Recommendation Report for Planning Permission for Works or Extension to a Dwelling

REF NO: P/86/21/HH

LOCATION: 41 Abbotsbury
Pagham
PO21 4RT

PROPOSAL: Erection of single storey rear extension following the demolition of existing conservatory

Mrs. Hoath
41 Abbottsbury, Pagham
West Sussex PO21 4RT
PROPOSED ELEVATIONS
Date: June 2021 Scale 1:100 Dwg.no.PR.EL.01

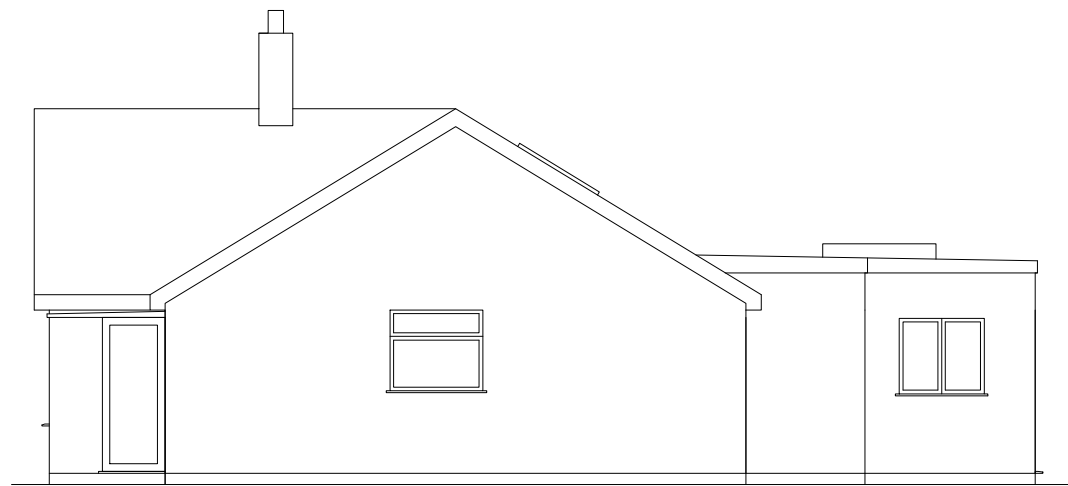
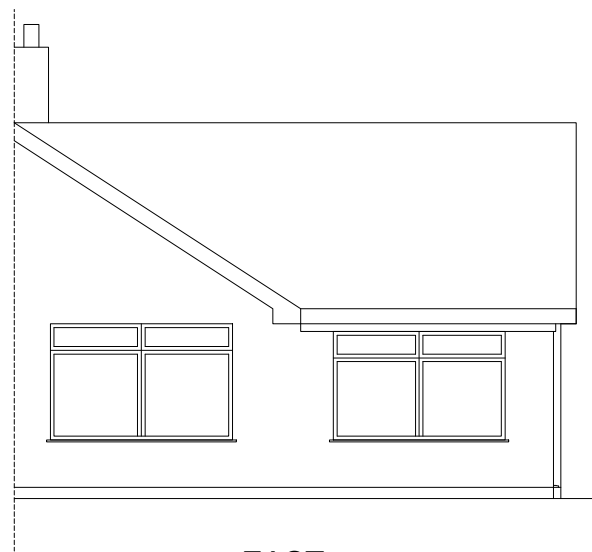
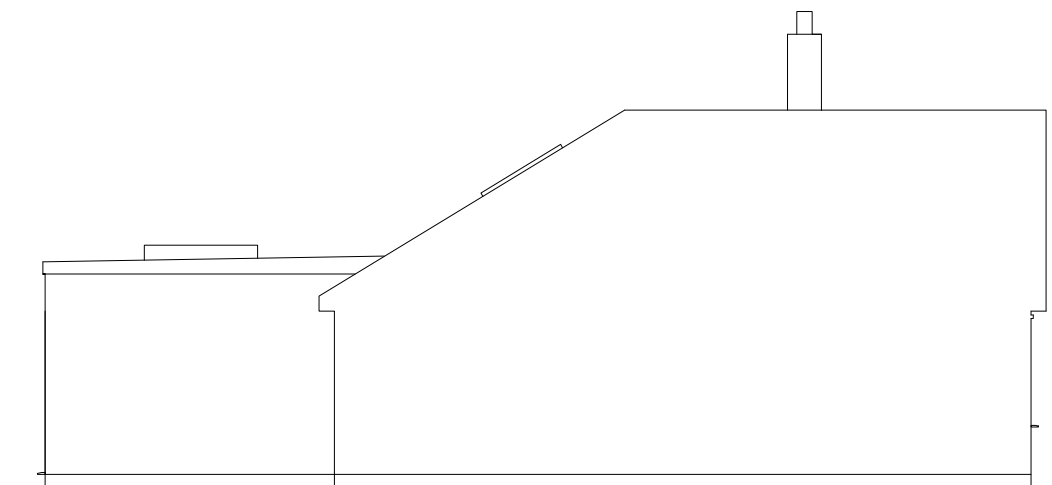
The proposals are for a single storey rear extension to replace the conservatory to be demolished to rear (west). Due to siting at rear (west) there will be restricted views from street scene or surrounding area so will not adversely impact street scene or surrounding character of area so complies with policy D DM1 of the Arun Local Plan. Whilst the flat roof design does not visually integrate with existing dwelling pitched roof, it is at single storey so is visually subservient to main dwelling so is acceptable.

The proposal will have a width of approximately 6.83m and a depth of approximately 3.87m jutting out from the west principal elevation and a depth of approximately 1.56m from the north west elevation. The height to flat roof will be approximately 3.03m and to top of roof light to 3.19m. There will be new triple folding doors to rear (west) and a new double window to side (east) of the extension. There will be a new door/two new windows to rear (north west) elevation of extension facing garden to rear (west).

Due to new triple folding doors to rear (west) elevation there is increased risk to overlooking to neighbouring properties to rear (west) however large gap of around 18m remaining to rear (west) boundary and location of boundary fence to rear minimises impact of overlooking to neighbouring properties to rear (west) so is acceptable.

Due to a new double window to east elevation of extension there is increased risk to overlooking to neighbouring property number 43 to north however due to gap of around 5.08m remaining to northern boundary and location of boundary fence to east there is no adverse harm to overlooking to north so is acceptable.

Due to a new door and two new windows to west elevation facing garden to rear (west) there is increased risk to overlooking to neighbouring properties to north however due to being at single storey and location of existing boundary fence to north there is no adverse harm to overlooking to north so is acceptable. Due to a large gap of around 9.31m remaining to rear (west) boundary and location of garage to north west boundary the impact to overlooking to properties to rear (west) is reduced so there is no adverse harm to overlooking to neighbouring properties to west so will comply.

Mrs. Hoath
41 Abbottsbury, Pagham
West Sussex PO21 4RT
PROPOSED FLOORPLAN & SPECIFICATION
Date: June 2021 Scale 1:50 Dwg.no.PR.FP.01

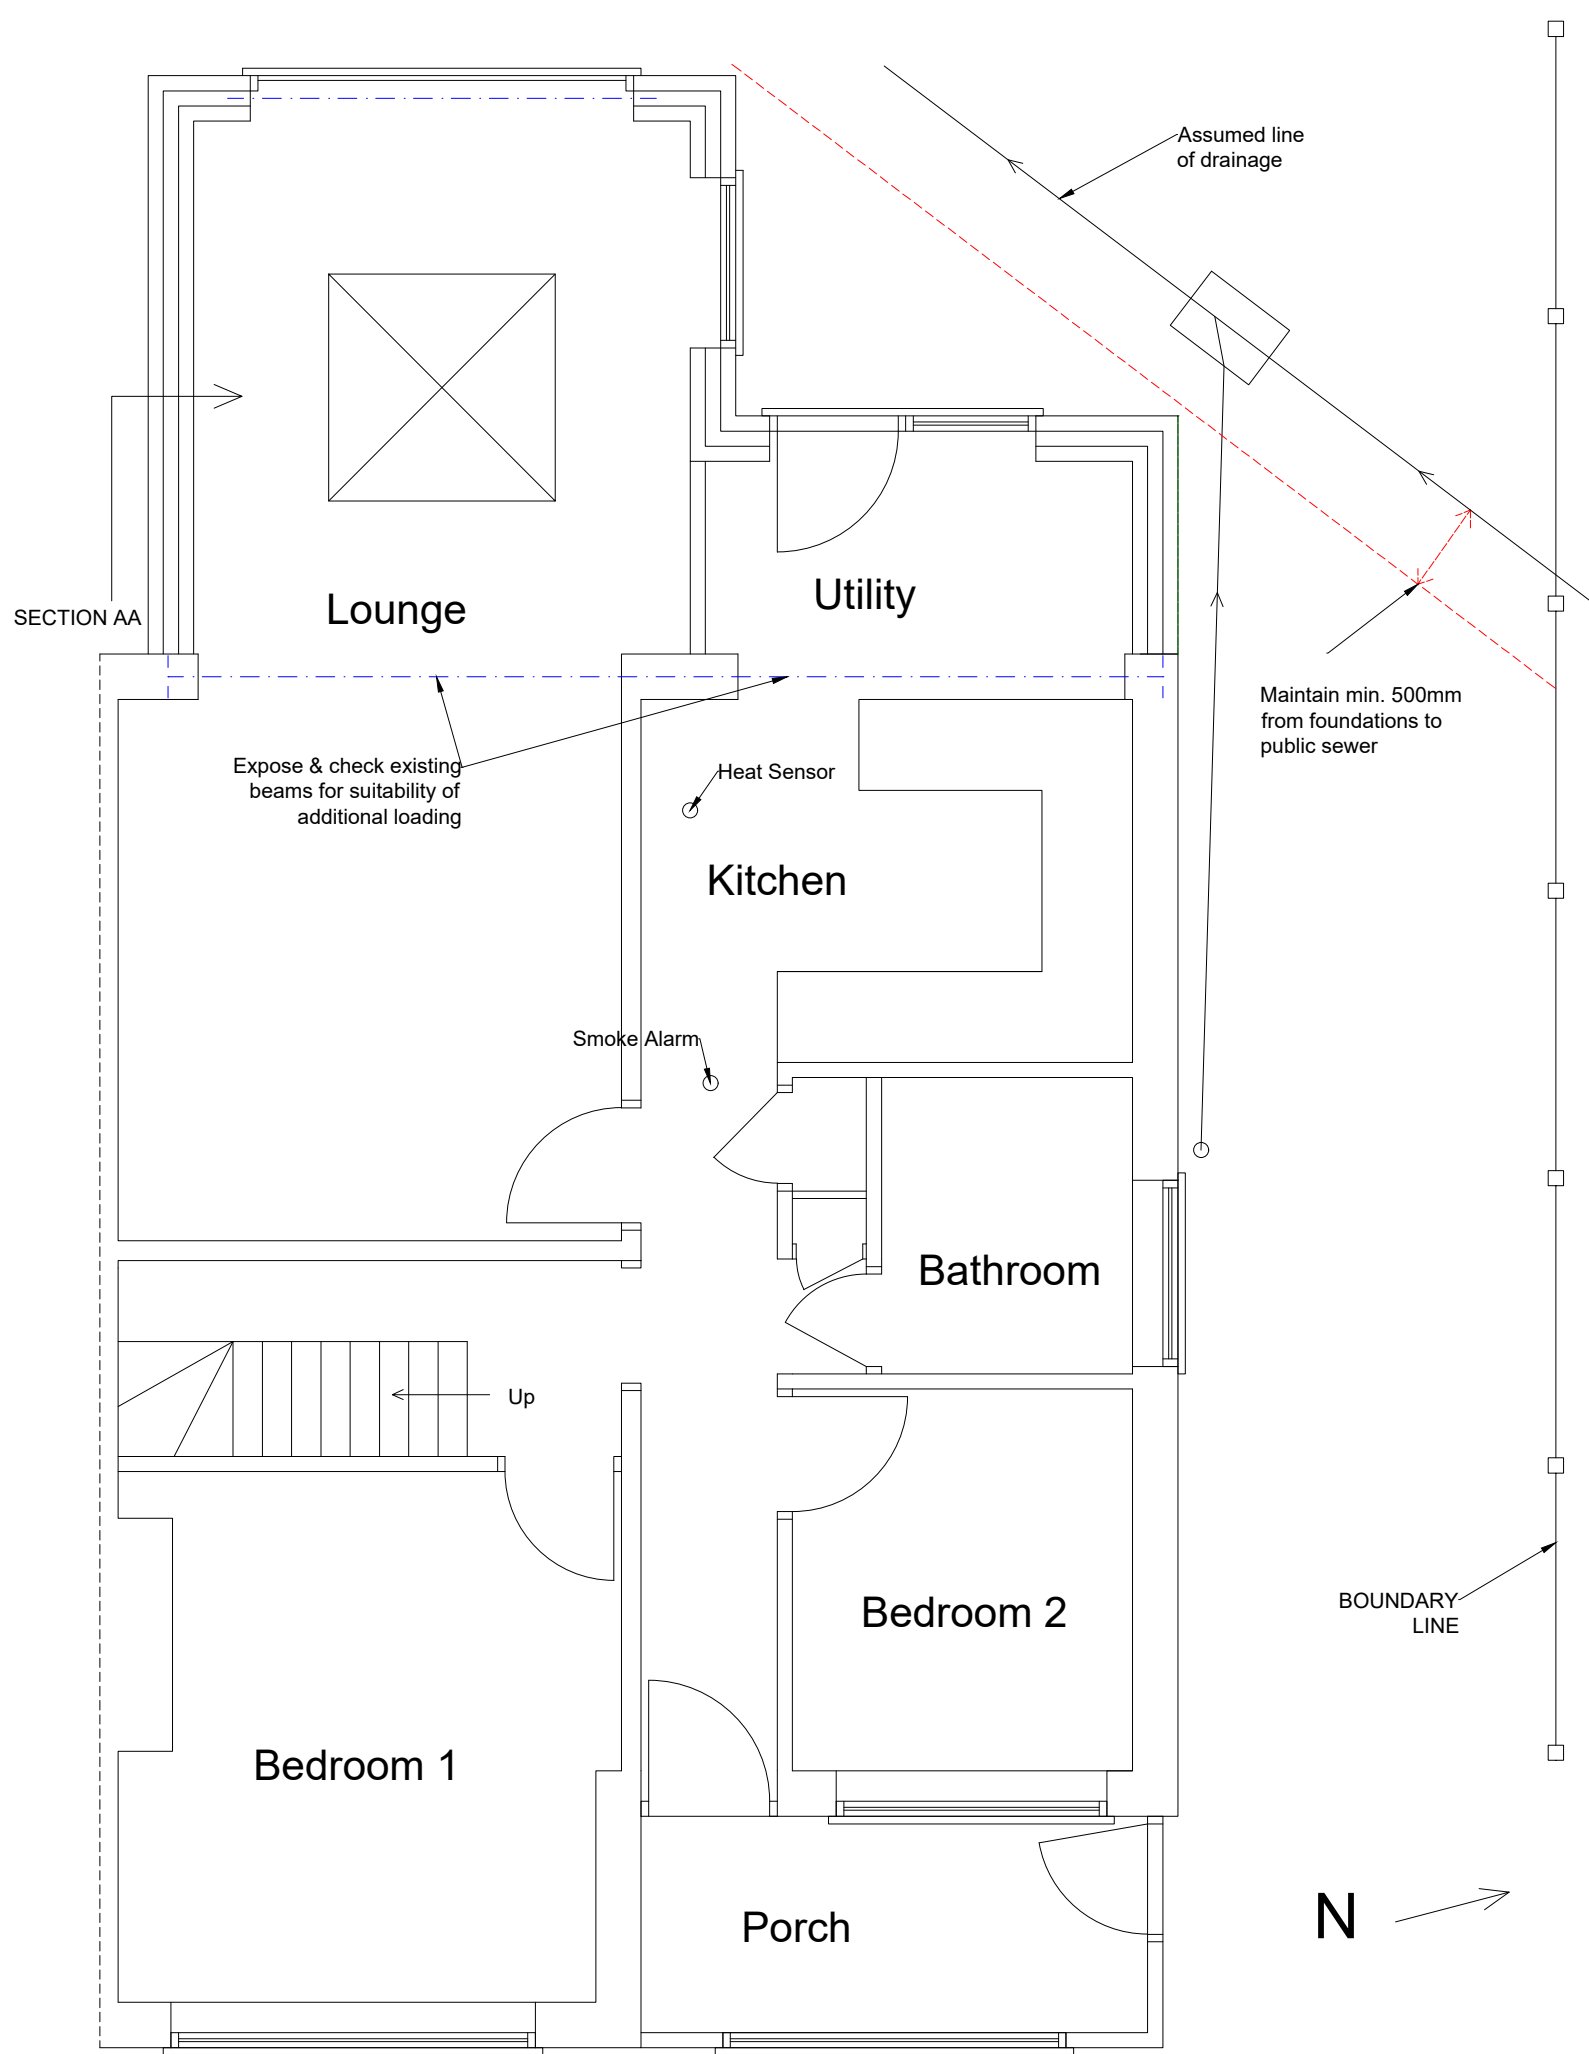
The materials seem to match dwelling and consist of brick walls, flat roof, UPVC double glazed windows and UPVC double glazed doors so comply with policy D DM1 and D DM4 of the Arun Local Plan.

PROPOSED SITE PLAN

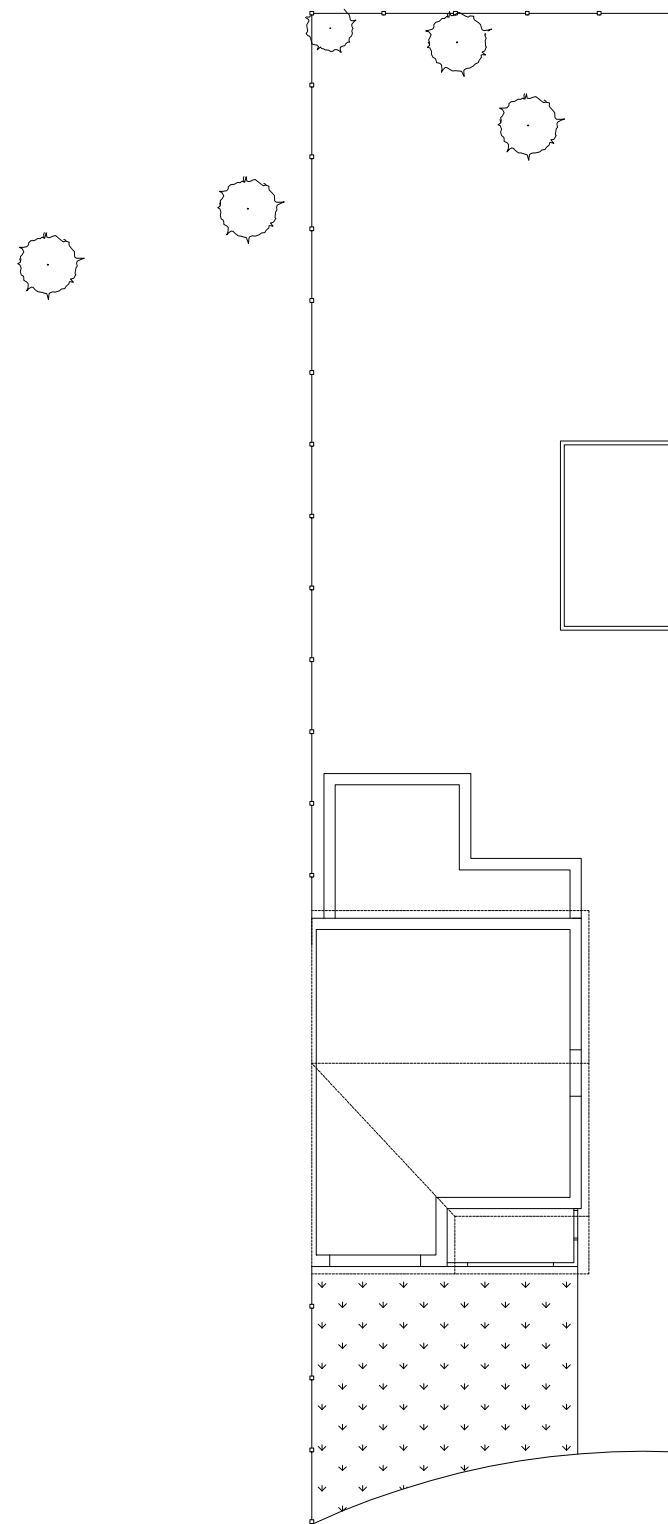
around 0.70m remaining to the south west boundary, gap to neighbouring property to south and being at single storey there is no adverse harm to overshadowing or overbearing effect to south so is acceptable.

Due to siting to rear (west) elevation there is increased risk to overshadowing or overbearing effects to number 43 to north however due to a gap of around 2.54m remaining to northern boundary, being at single storey and the siting of garages to neighbouring property northern boundary there is no adverse harm to overshadowing or overbearing effects to neighbouring property to north so is acceptable.
